Proposed Poultry Unit, Land
at Peartree Hill Road,
Whaplode Drove, Spalding

Review of Air Quality and Particulate Matter Assessments

Date: 20/6/25

Figure 2. Emission rates in 2022 for each of the three crop cycles –House 1 (maximum stocking 30 kg/m²), 46,010 birds initially stocked

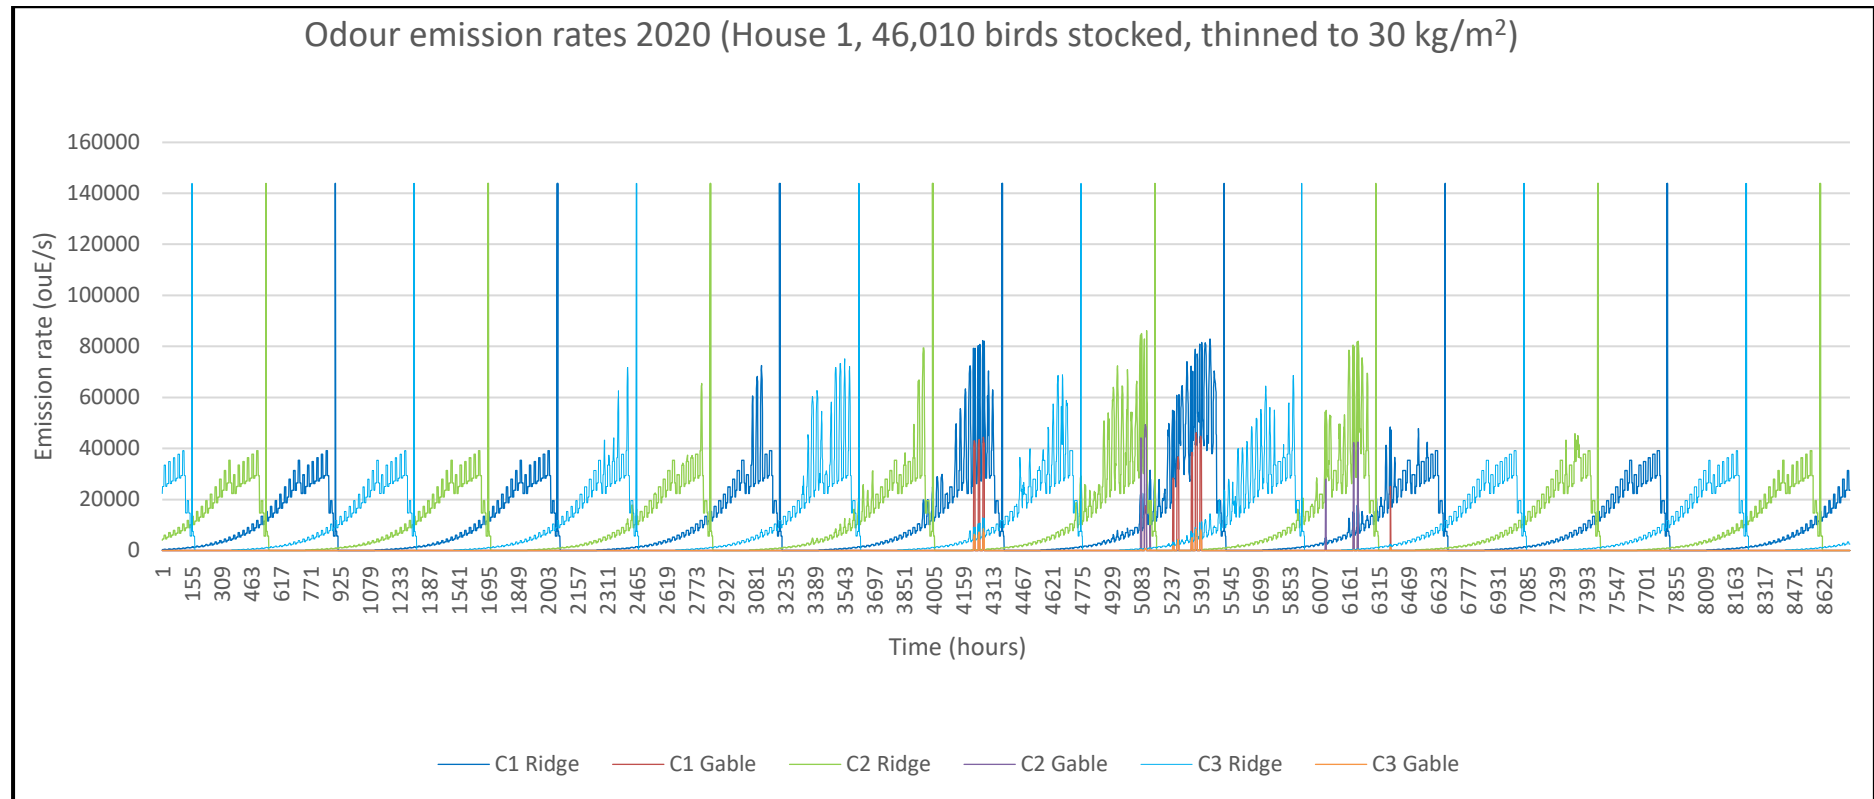
The odour emissions have been calculated by assuming that odour concentrations in the houses are 300 ou_E/m³ at day 1, increase to 700 ou_E/m³ at day 16, 1800 ou_E/m³ at day 30 and “approximately” 2,300 ou_E/m³ at day 34. These figures were obtained by a paper published by Robertson¹⁴ for a poultry house with 34,000 birds. However, the Robertson only reports odour concentrations “around day 16” as 600-800 ou_E/m³ and 1300-2300 ou_E/m³ around day 30. The assessment has used the average of the range quoted, not the worse case and the figures used for the start of the cycle (300 ou_E/m³) and day 34 (2,300 ou_E/m³) are not quoted in the paper.

This illustrates the potential range in values that can be found in poultry houses, all studies have reputable authors and no study could be considered to be “better” than another. However, if the EA study figures were used in the same manner to calculate the odour emission rates, the resulting predicted odour concentrations would be more than double those predicted in the report and would

The odour emission rates are calculated in the applicant's report for each hour of the year by multiplying the ventilation rate by the internal odour concentration. The ventilation rate is based on the day of the crop cycle and the external temperature. Lower ventilation rates will occur at the beginning of the rearing cycle and/or in cooler weather. At high ventilation rates an adjustment is made to the assumed concentrations, it is stated that *"if the calculated ventilation rate exceeds that required to replace the volume of air in the house every 5 minutes, internal concentrations are reduced (by a factor of the square root of 7.5 times the shed volume/divided by the ventilation rate as an hourly figure)"*. This adjustment reduces the odour emission rate (and hence the odour impact) at higher ventilation rates. There is no supporting justification for the manner in which this adjustment is made in the applicant's report. MBAL has frequently noted this in similar reviews of AS Modelling and Data Ltd.'s reports and the data to support this adjustment has not been made publicly available.

Figure 4. The positions of modelled buildings and sources

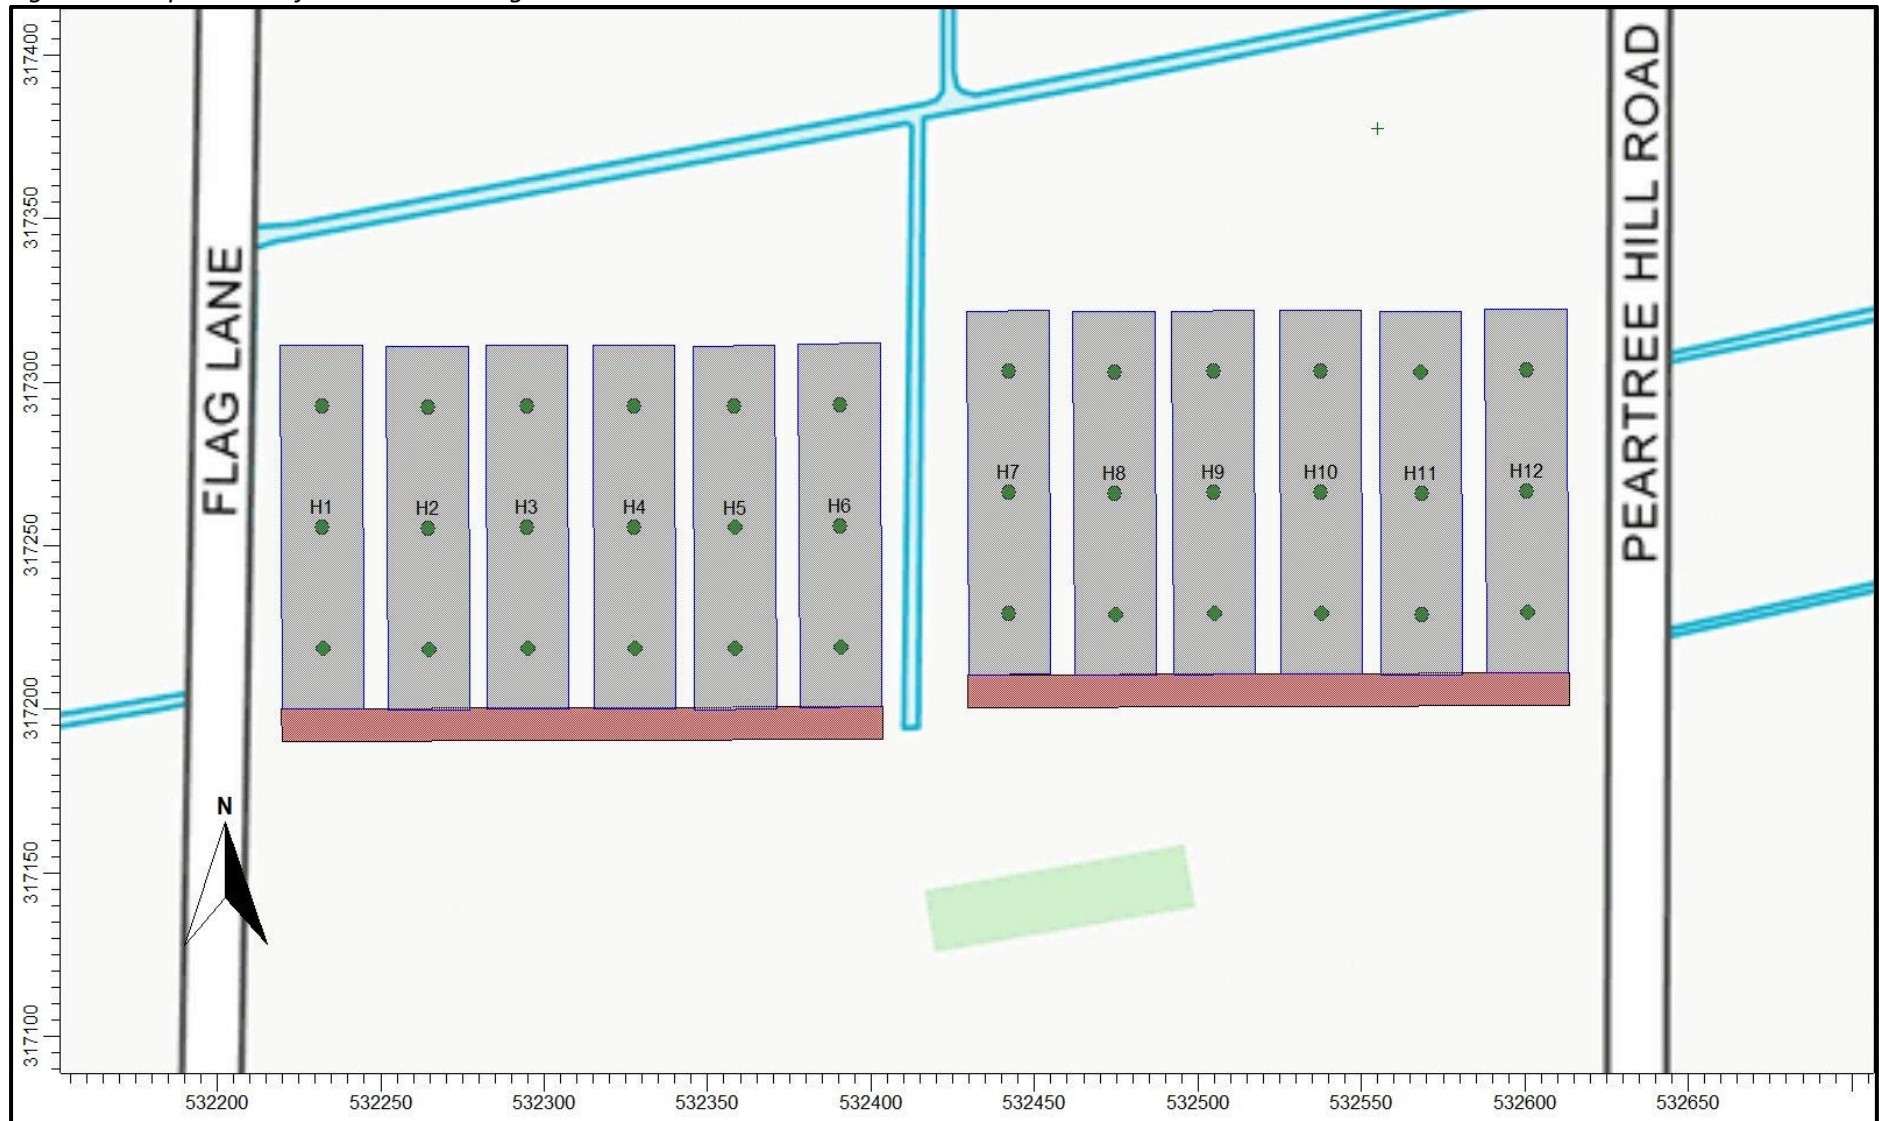
The model has been set up with point sources to represent the roof mounted fans and volume sources to represent the gable end fans, these are both appropriate approaches.

Building structures can affect the initial dispersion of pollutants and the model used can take this into account. Building dimensions are included as model input to allow for modelling of building downwash for the poultry houses. The data used in the model is provided in line with good practice.
